DEVELOPMENT REVIEW COORDINATOR
POST APPROVAL PROJECT CHECKLIST

Project Name: Mixed Use Development - Veroneau

Project Name: **Mixed Use Development at 321 Commercial Street (corner Maple Street)**
Project ID: 2012-615 CBL: 40-E-3
Address: 321 Commercial Street
Applicant: J B Brown & Sons
Planner: Jean Fraser

**DATE:** 10-22-12  
**SCALE:** 1"=20'  
**DRAWN BY:** EJS  
**C08**  
 SHEET 8 OF 14

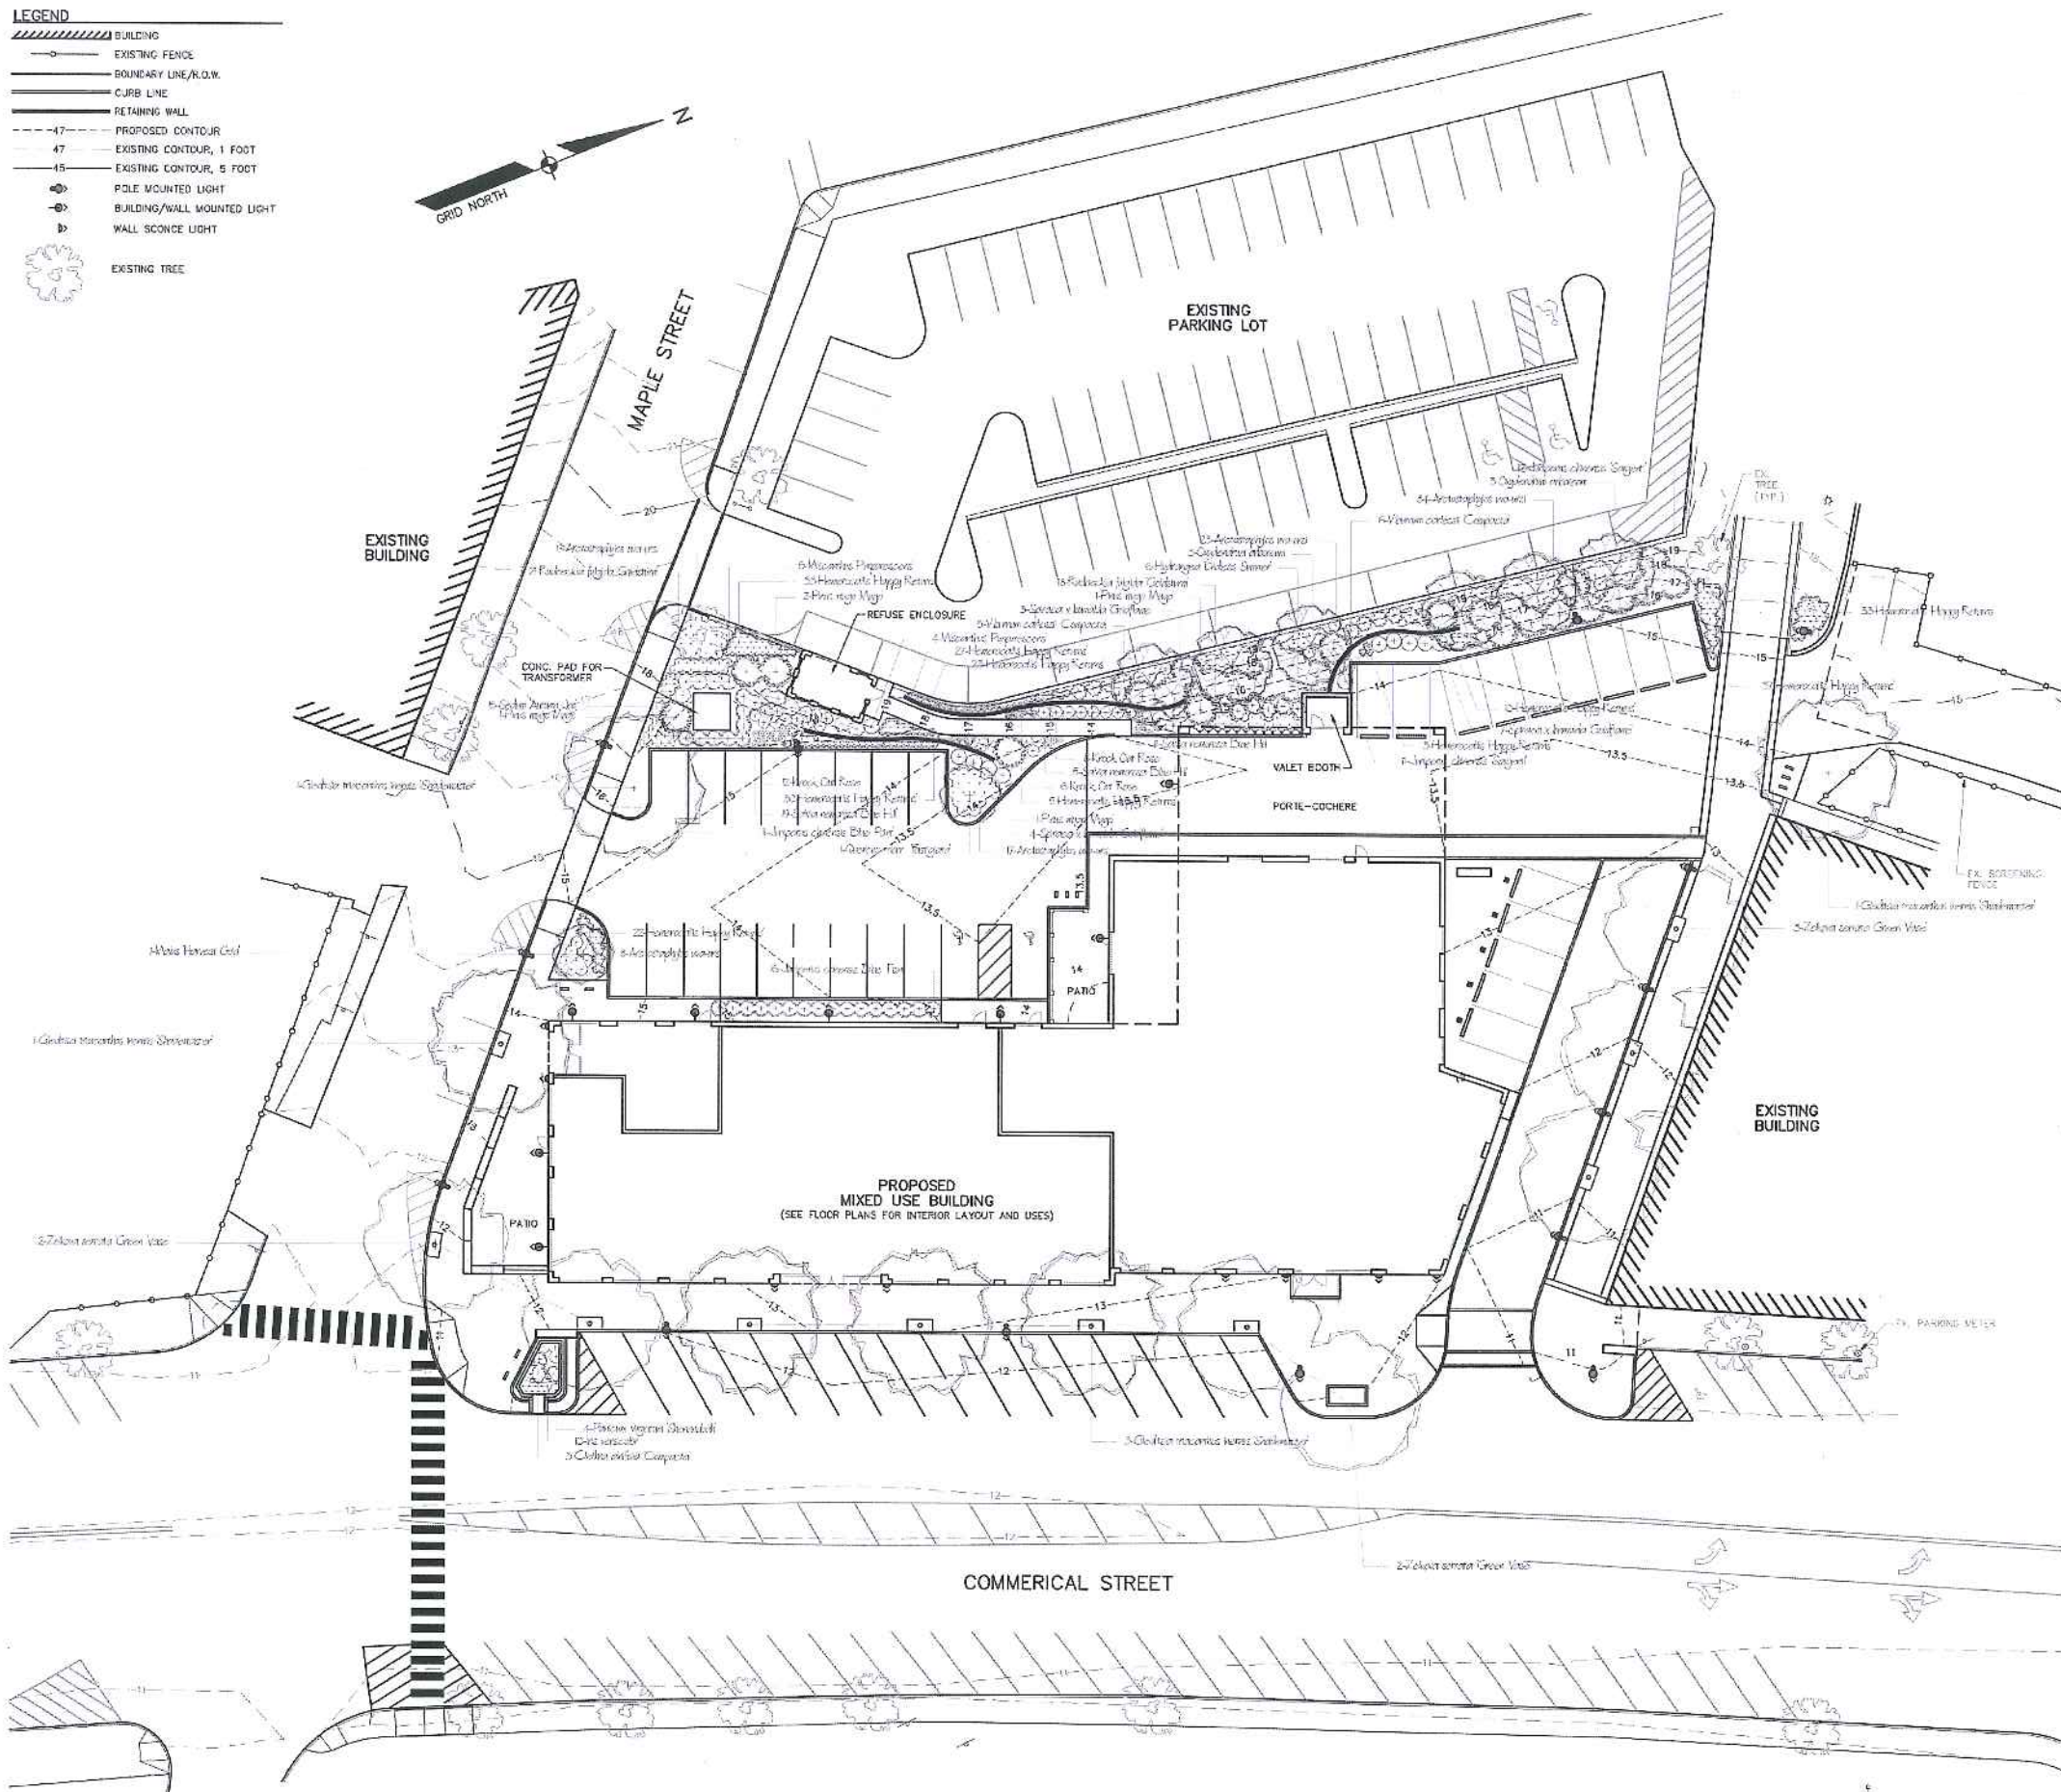
- 5. That the applicant shall submit a revised Landscape Plan that demonstrates the provision of 14 street trees, however the applicant need not place a street tree within the patio, and shall otherwise address the comments of the City Arborist dated January 11, 2013, and include details of the sidewalk construction and associated replacement planting along Maple Street between the new site entrance and York Street, for review and approval by the City Arborist and Planning Authority prior to the issuance of a building permit; and

- a) Street-trees - I would recommend the Zelkova trees selected for the Commercial Street frontage be the Zelkova 'Musashino' variety vs 'Green Vase'. The Musashino types are more narrow vase shaped 45' tall by 20' wide vs 50' tall by 40' wide. This will fit in next the proposed development with less canopy impact in the future.

- b) Maple Street entrance planting area - this area is well landscape in regards to the number of plants, however, the planting lacks height. An additional two or three trees within the landscape area should be included as a condition. The plant / tree types and location would be flexible to fit into the overall theme of the proposed project. Suggested tree types could be River Birch, American Hornbeam, Three Flower Maple, Katsura, Magnolia... Metasequoia, Swiss Stone Pine, Serbian Spruce for conifers. This could be in place of the proposed Mugo Pines.

- c) Rain-garden Planter - The 321 Commercial Street project will install the first commercial rain garden planter in Portland. We would be willing to assist on the planting types if interested.

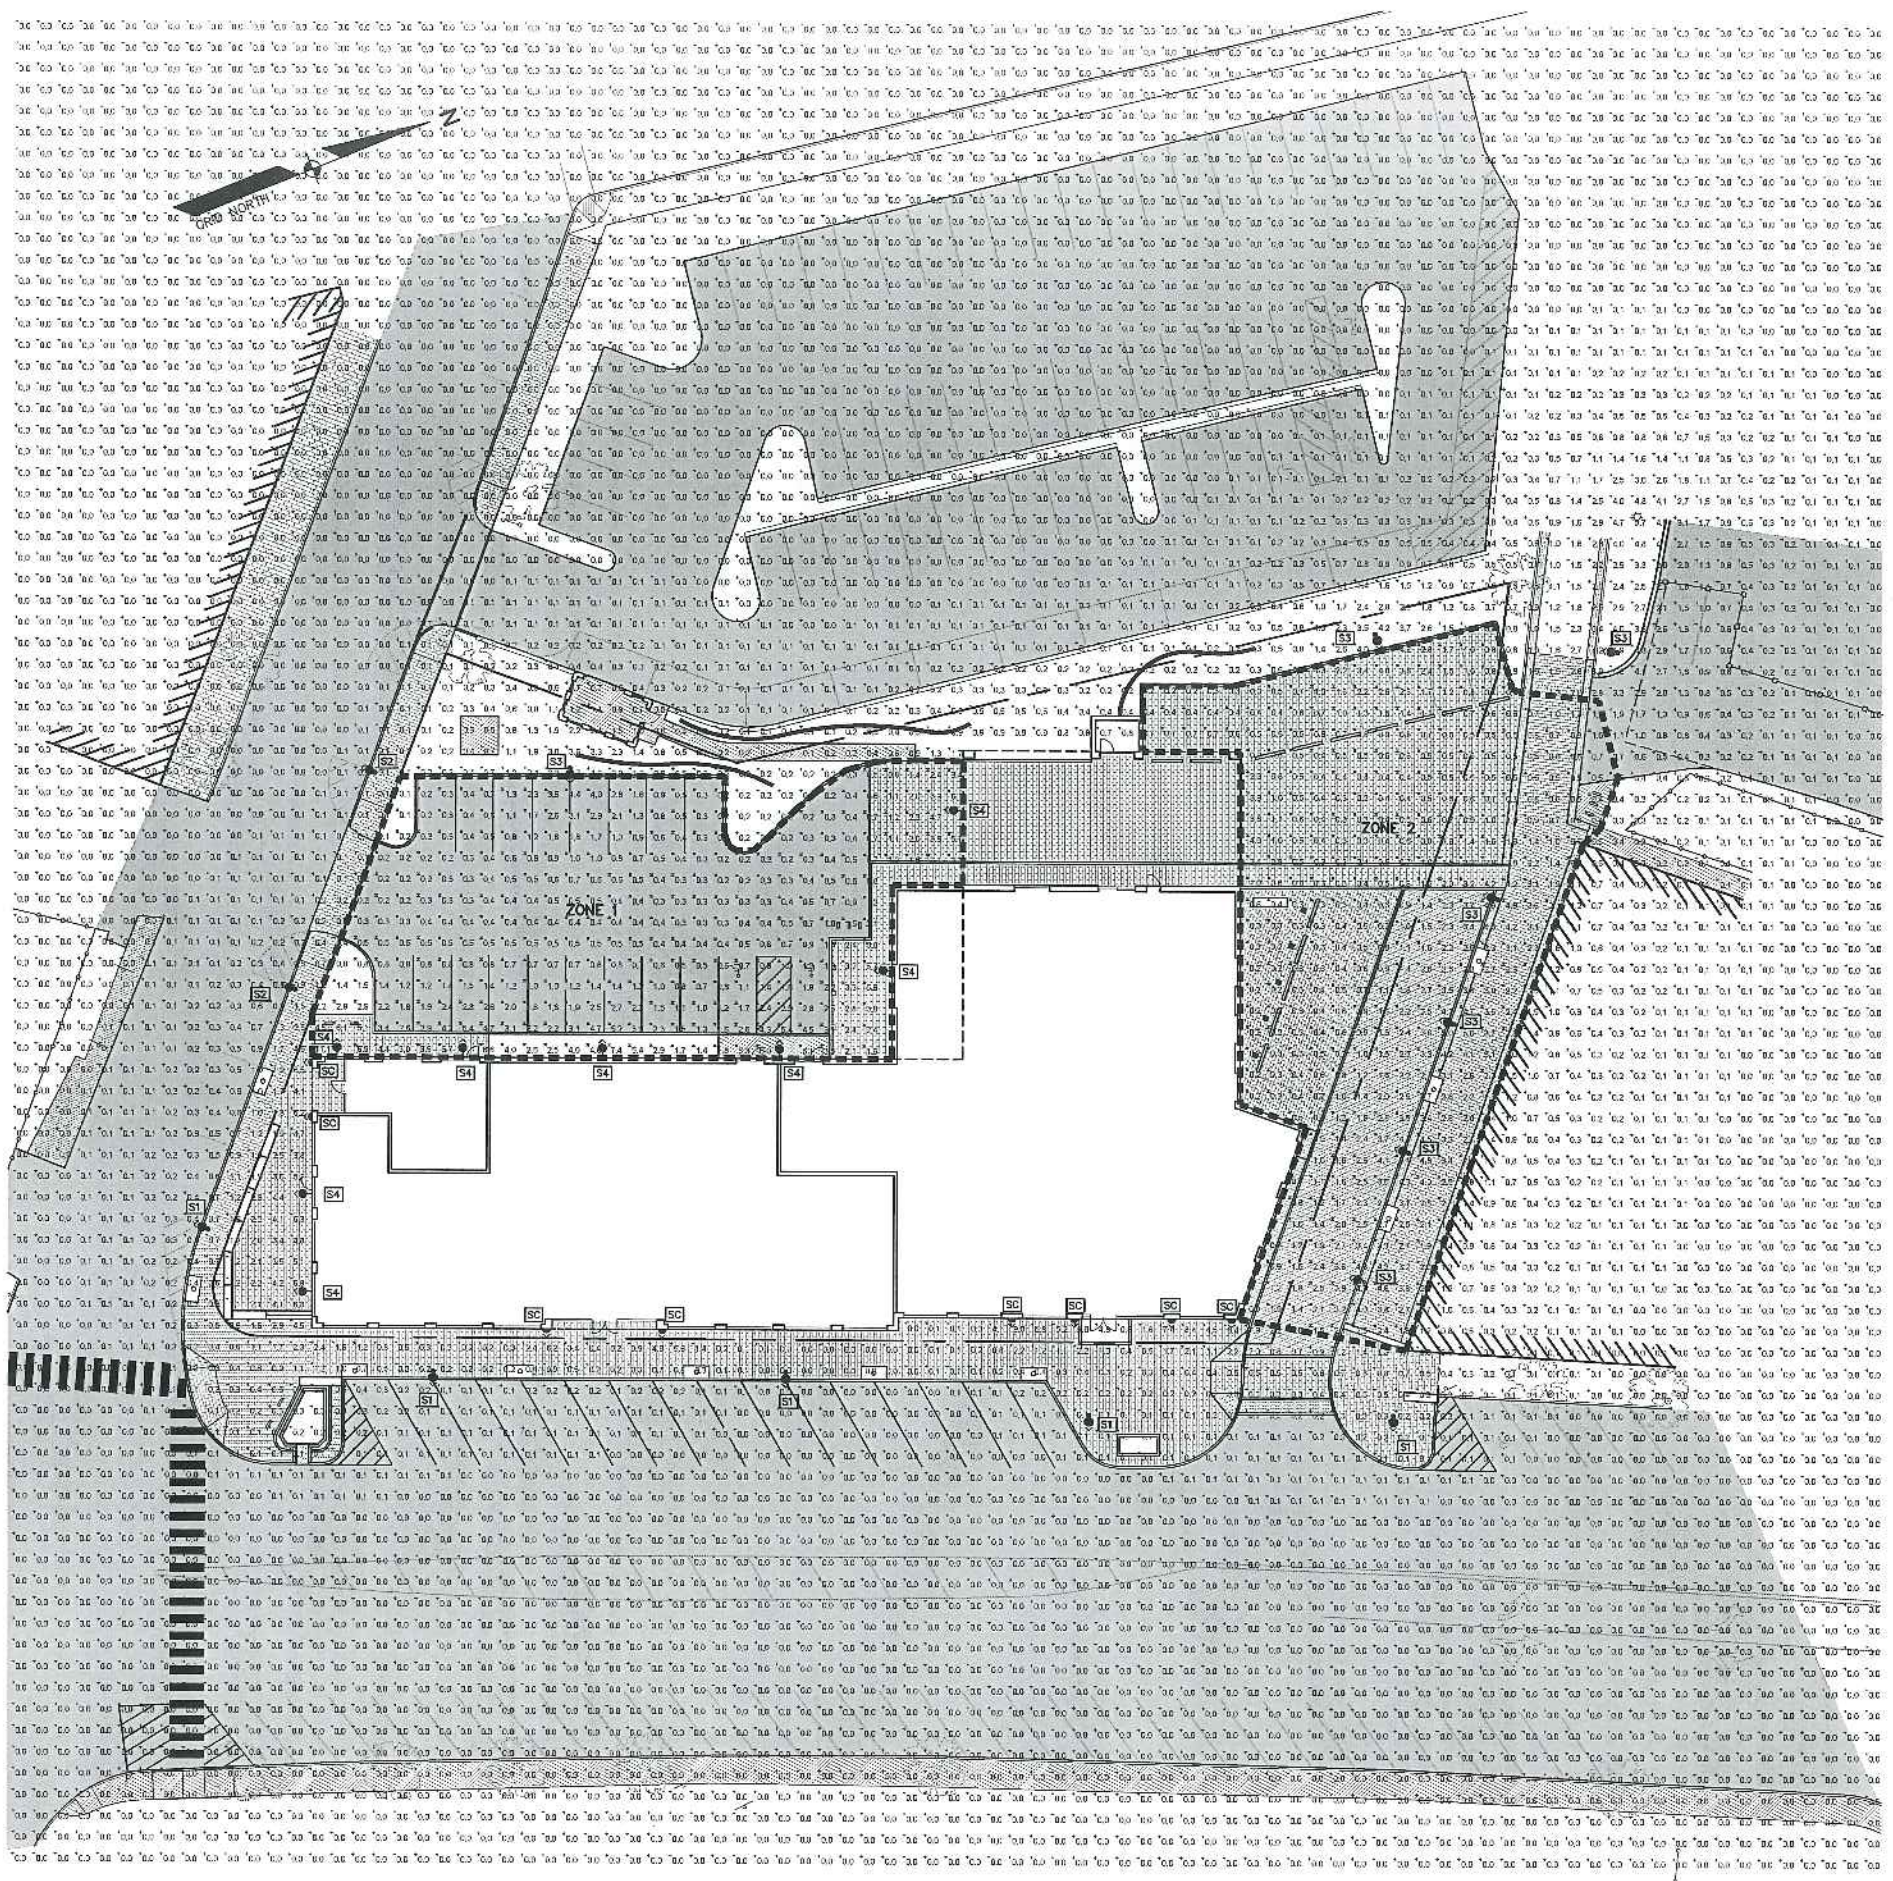
The Planning Board waives Technical Standard, Sections 12.2.3 Illumination Levels and 12.2.5 Light Trespass, to allow 10 locations near the building where maximum light levels are exceeded by up to 4 foot candles, and to allow some minor trespass at the property boundaries that benefit the pedestrian areas.
